**From:** Contact Centre (CRM) <contact@ribblevalley.gov.uk>  
**Sent:** 08 April 2024 20:09  
**To:** Planning  
**Subject:** Planning Application Comments - 3/2024/0201 FS-Case-603948422

**Planning Application Reference No.:** 3/2024/0201

**Address of Development:** 21 Abbots Croft Whalley

proposed plan

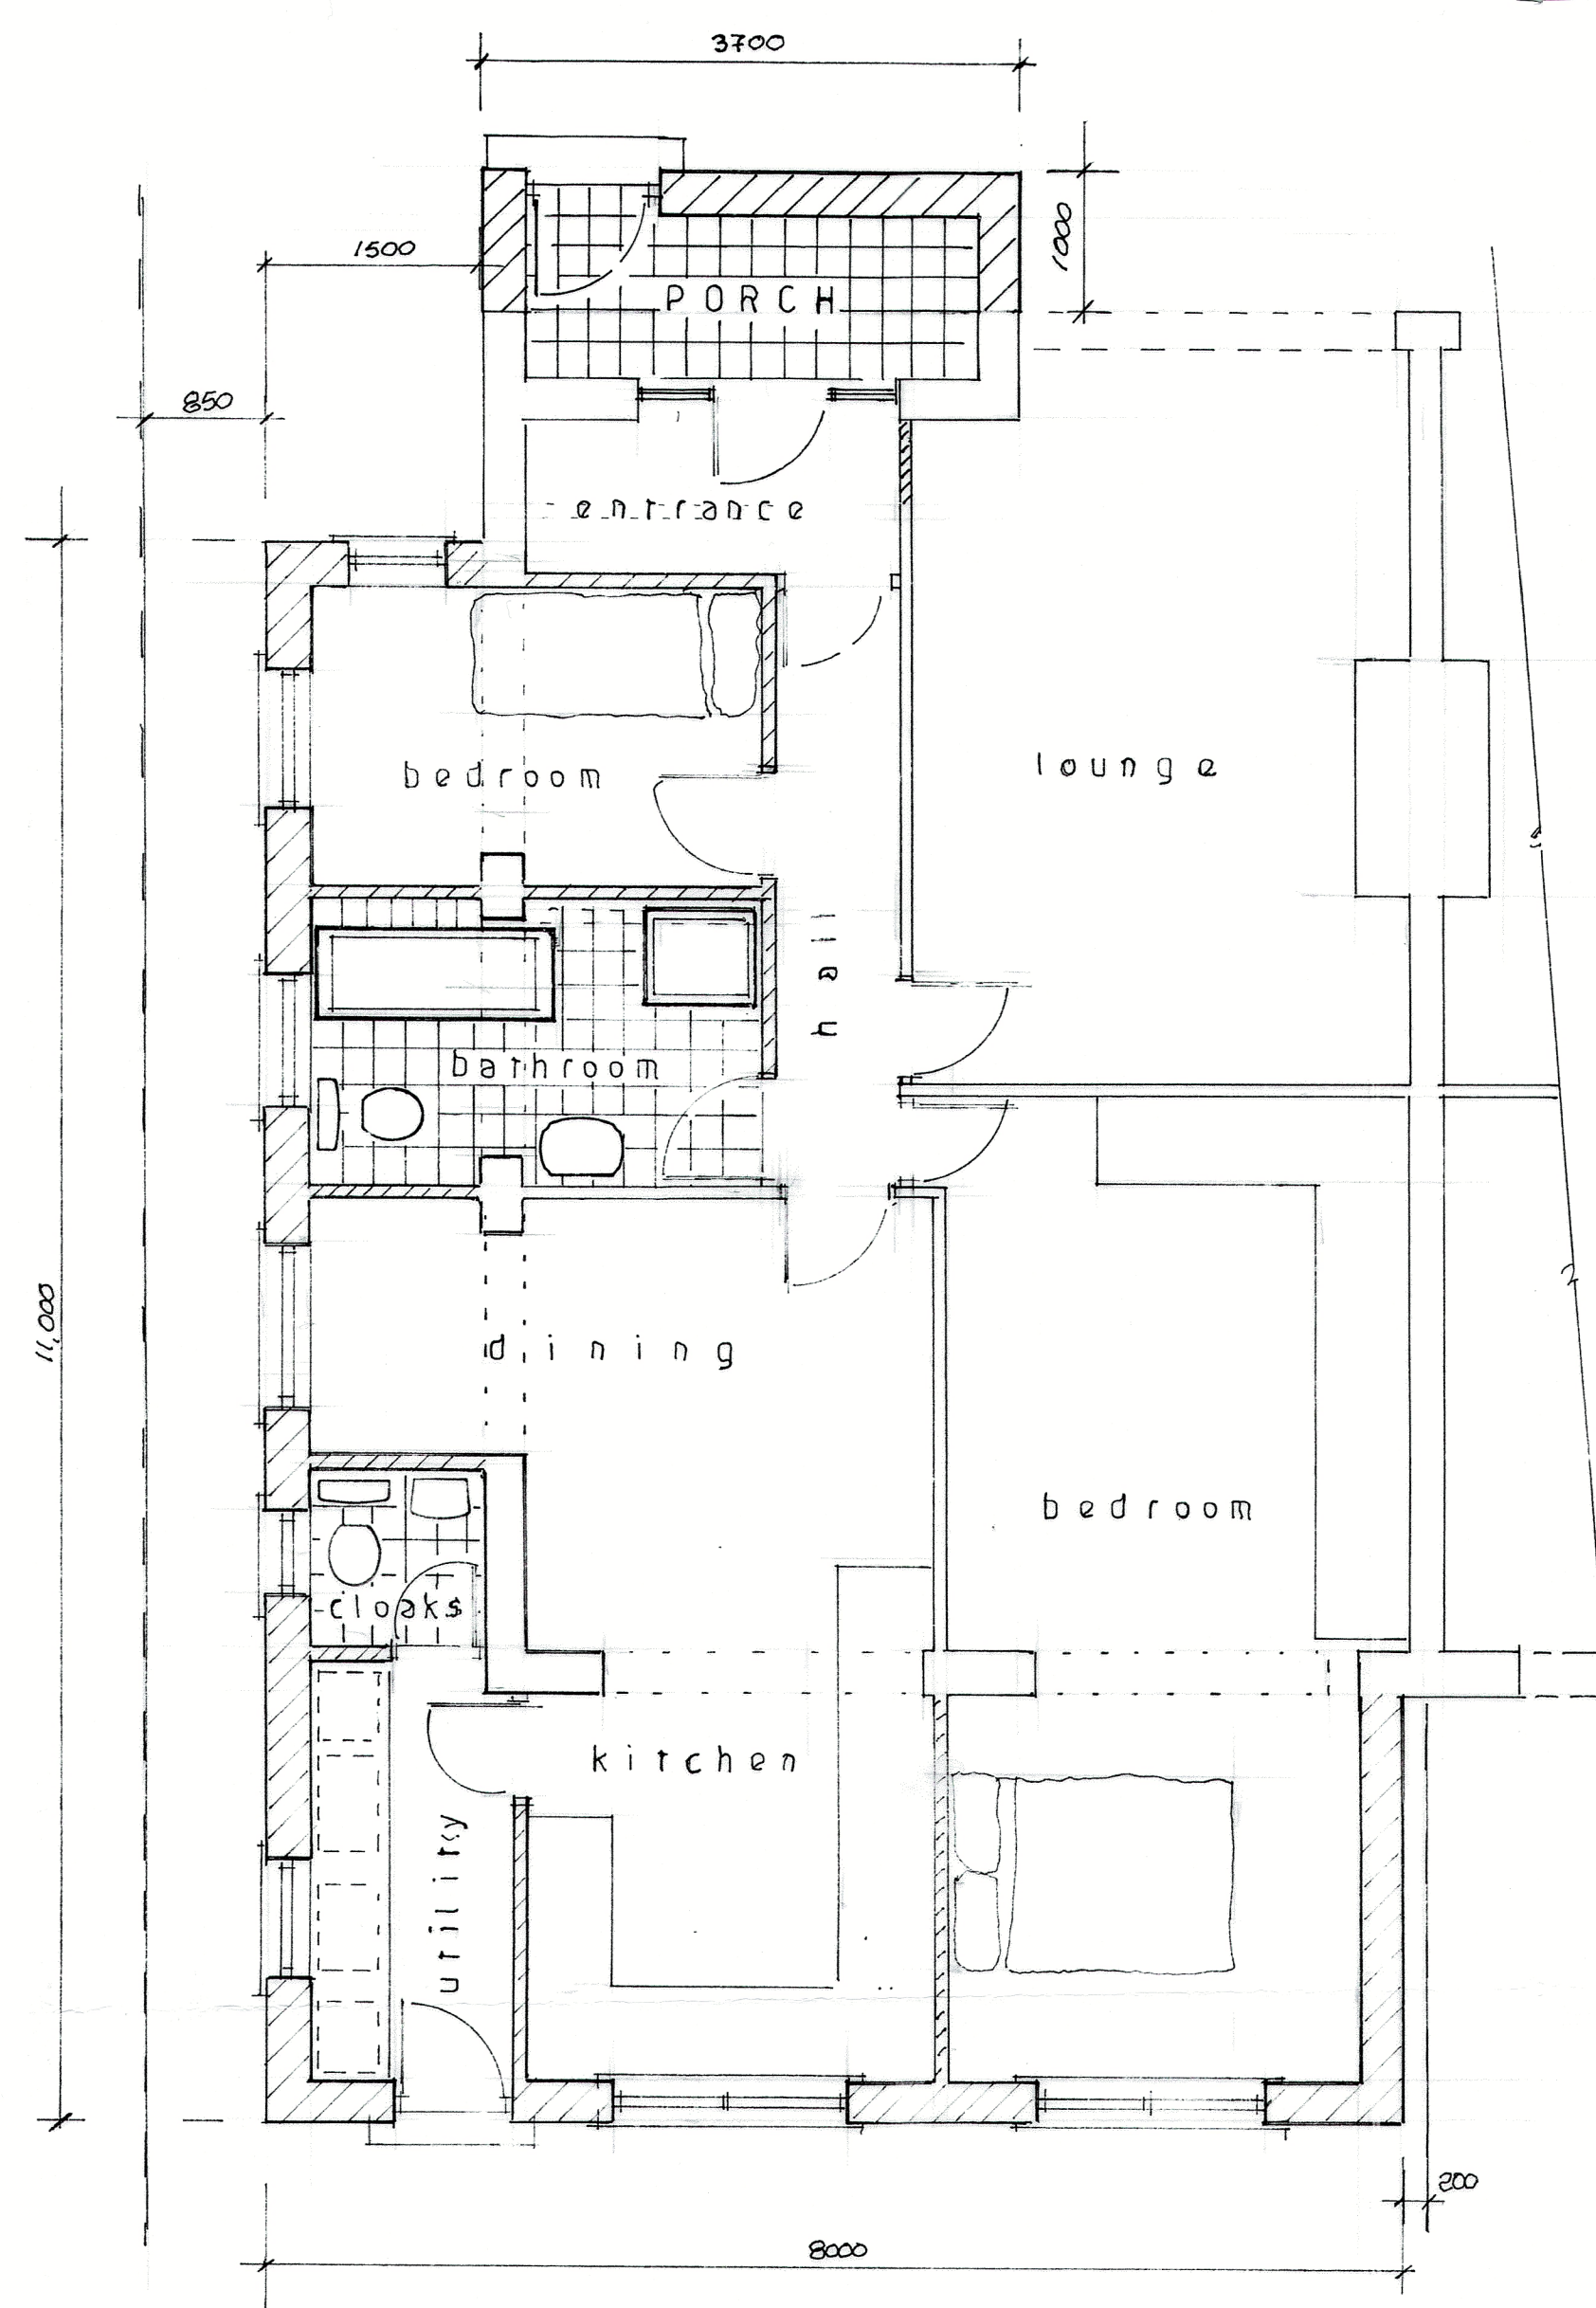
**Comments:** The extension to the rear of the property is far too large and will [REDACTED]  
[REDACTED]. This rearward extension is also excessive  
filling almost the whole of the plot.

**Comments:** [REDACTED]. This development will severely encroach [REDACTED] as it [REDACTED]. In addition there is no detail as to how the extension is to be joined to the existing walls and it fills the plot so completely that it will be impossible for the owner to maintain [REDACTED]. This is particularly important as the plan envisages a gutter and down pipe on that adjoining wall which will fill with moss etc [REDACTED] and cause moss and mould growth. There should be a maintenance space between that wall and the [REDACTED] of at least 1m.

Finally the application states that the development will not affect the parking facilities at the property which is wholly untrue as parking currently is in the garage and at the side of the property and on the front driveway with space for 3 vehicles whereas after the development the garage will be inaccessible and the side of the property will be inadequate for parking purposes. The amended bungalow will have two bedrooms but only space for one car on the driveway. The width of Abbots Croft is inadequate for permanent parking yet there would be a requirement for two vehicles from the property to park on it.
